CITY OF ALBUQUERQUE

Site: O'Reilly Auto Parts- 6380 Coors Blvd NW

Re: Drainage Ordinance (14-5-2-1) Violations for Erosion and Sediment Control and Construction Site Wastes

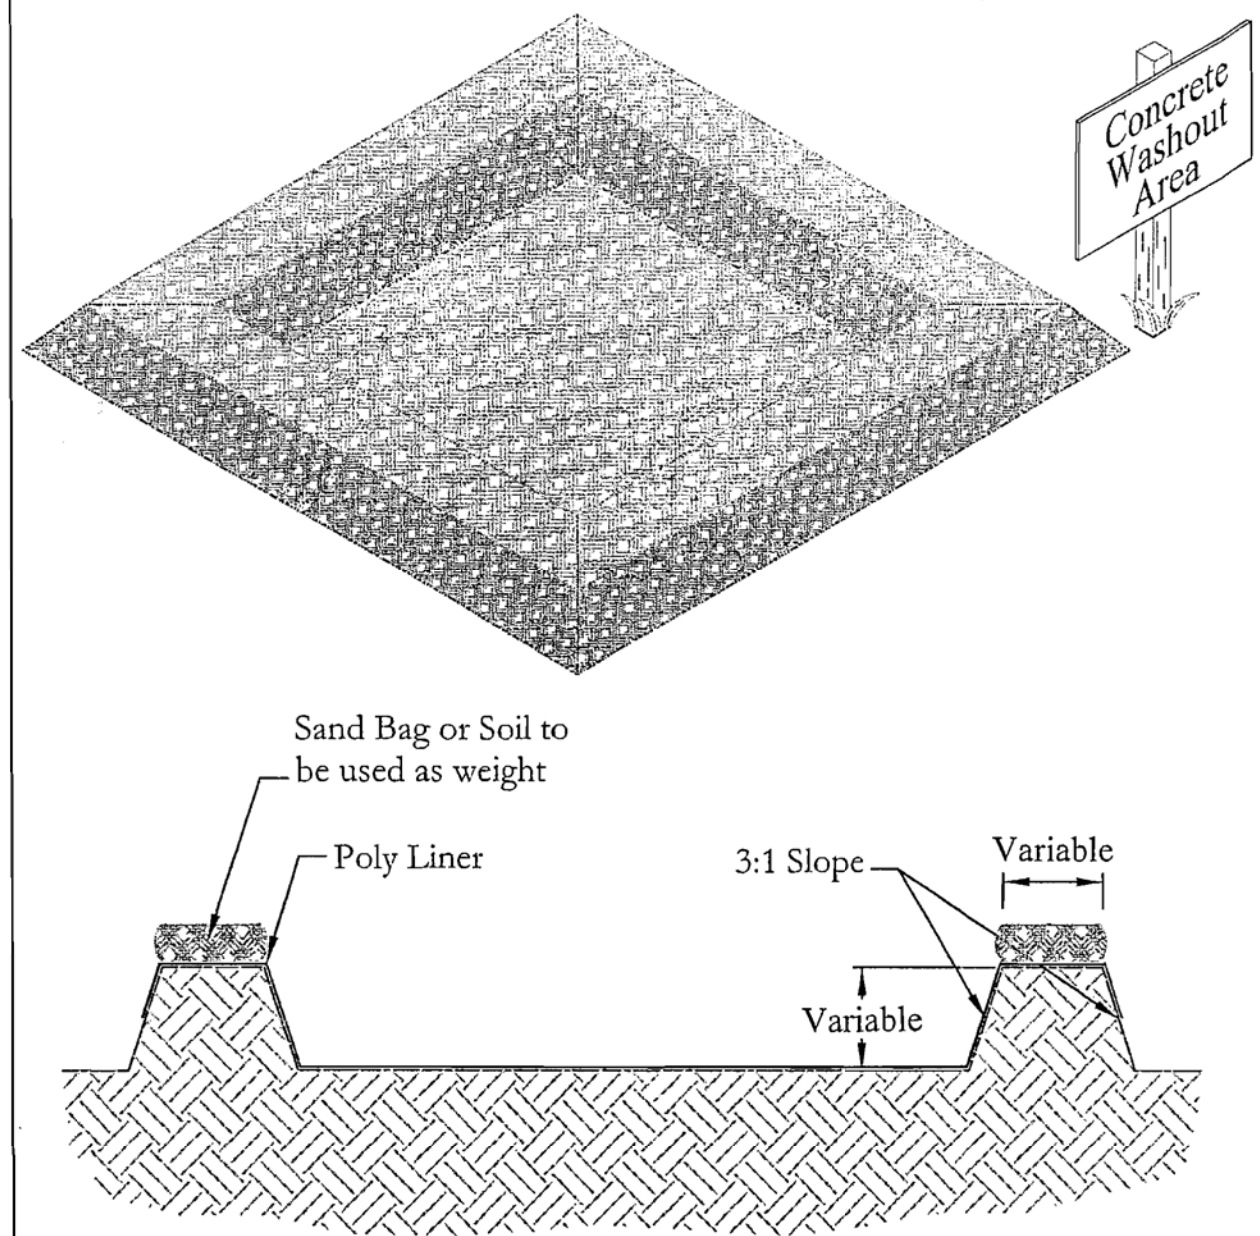
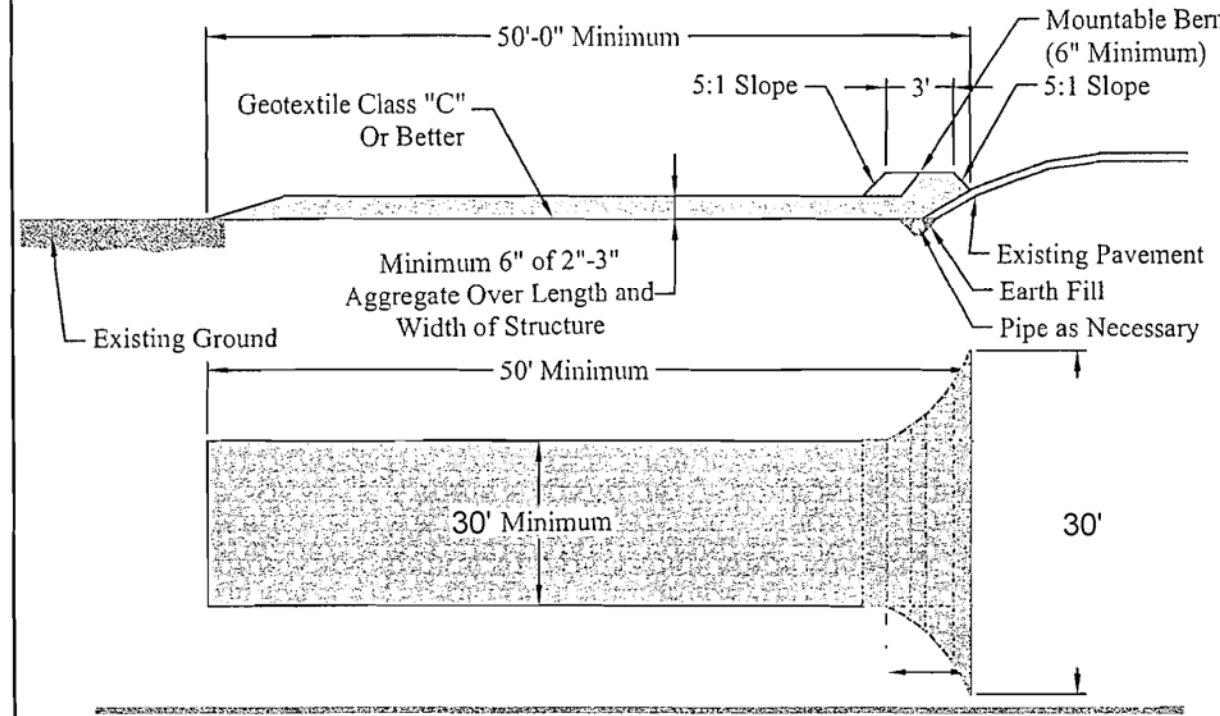
1. Numerous wash-outs in the dirt.
2. Trash/construction site wastes not in an acceptable container.
3. Waste container full and not covered when it was not in use.
4. Sediment BMP along southern edge requires maintenance.
5. Site posting not readable from the street.

1. Remove wash-out from the dirt and have workers use the acceptable wash-out in the future.
2. Trash/construction site wastes are to be in an acceptable waste container.
3. The waste container is to be covered when it was not in use.
4. Maintain the sediment BMP along southern edge.
5. Maintain the site posting so it is readable from the street.
